HYDRANT CONDITION CONSULTATION WITH PLANNING AUTHORITY

Planning Ref: BN/62/21/PL

Address: The Croft Surgery, Barnham Road, Eastergate, West Sussex,
PO20 3RP

Description: Medical centre with pharmacy retail unit & other ancillary uses
together with access onto Barnham Road, associated car
parking and other hard and soft landscaping works. This site
is in CIL zone 2 (Zero Rated) as other development.

PROPOSED SITE PLAN

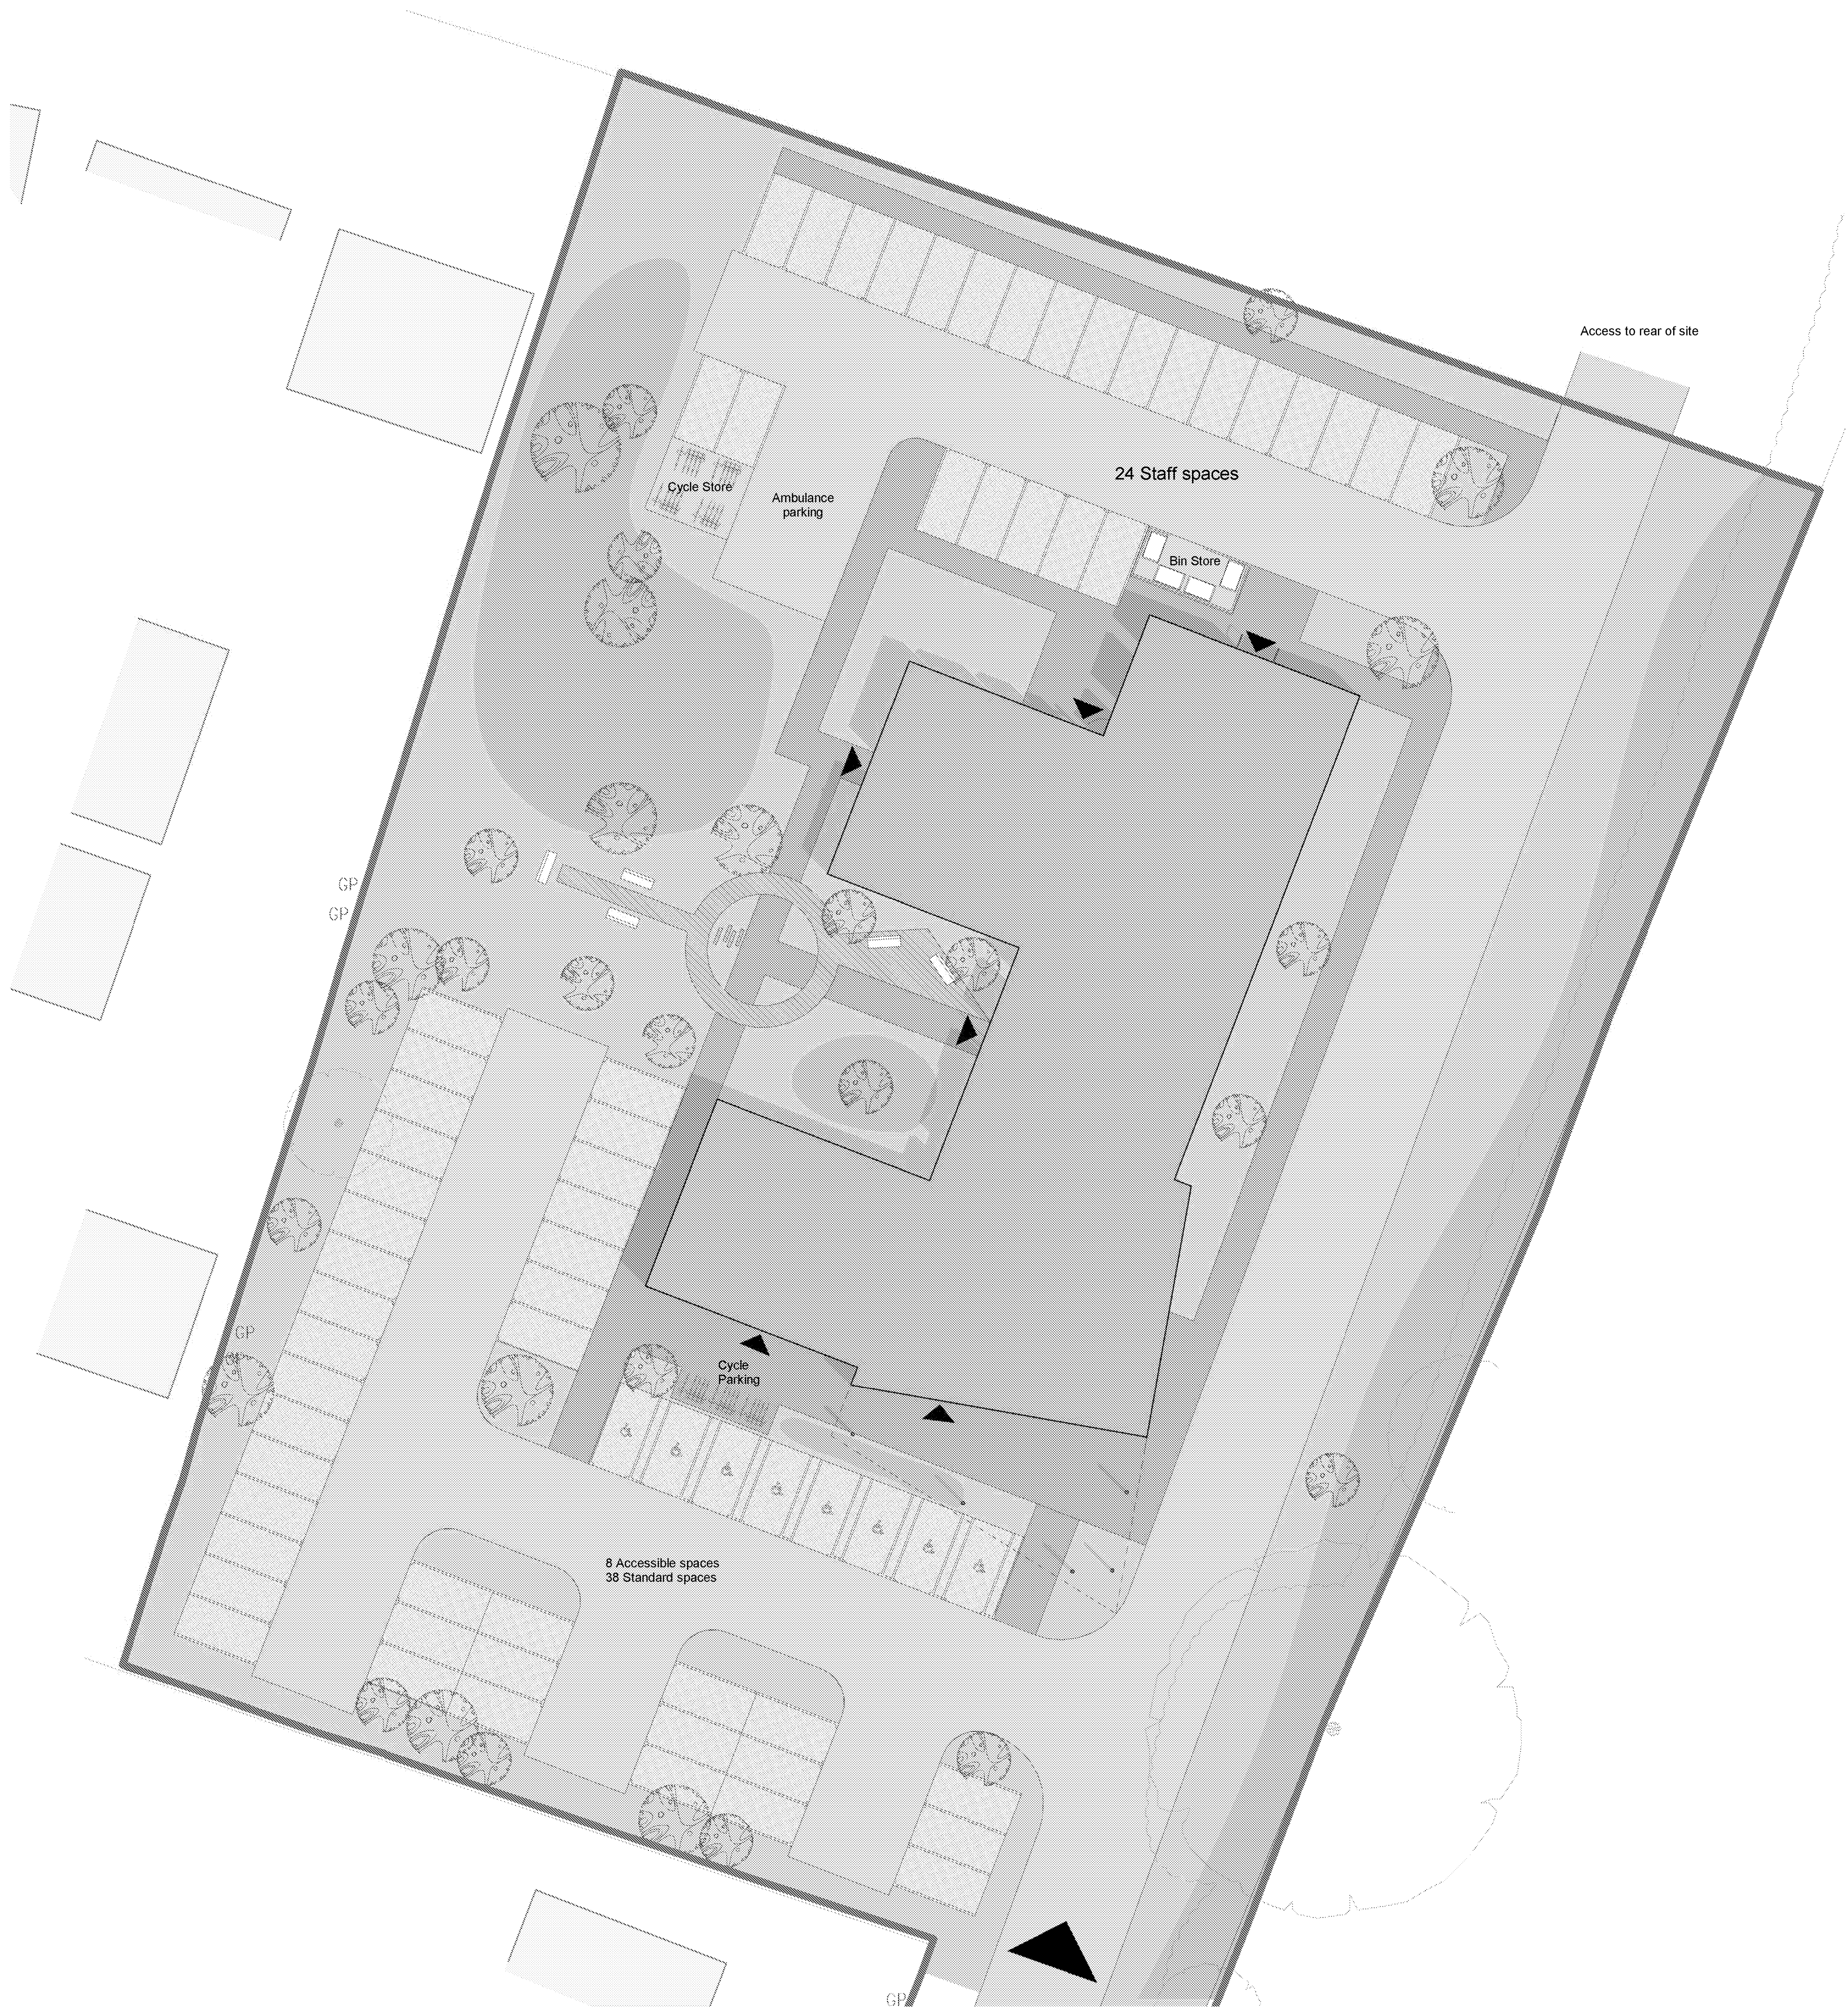
Please find attached a planning condition for application no. BN/62/21/PL for the requirement of an additional fire hydrant. Currently the nearest Hydrant to these proposed properties is 270 metres away. The supply of water for firefighting for a commercial premises should be within 90 metres.

- 1) Prior to the commencement of the development details showing the proposed location of [1] one fire hydrant or stored water supply (in accordance with the West Sussex Fire and Rescue Guidance Notes) shall be submitted to and approved in writing by the Local Planning Authority in consultation with West Sussex County Council's Fire and Rescue Service. These approvals shall not be unreasonably withheld or delayed.
- 2) Prior to the first occupation of any dwelling/unit forming part of the proposed development that they will at their own expense install the fire hydrant in the approved location to BS 750 standards or stored water supply and arrange for their connection to a water supply which is appropriate in terms of both pressure and volume for the purposes of firefighting.
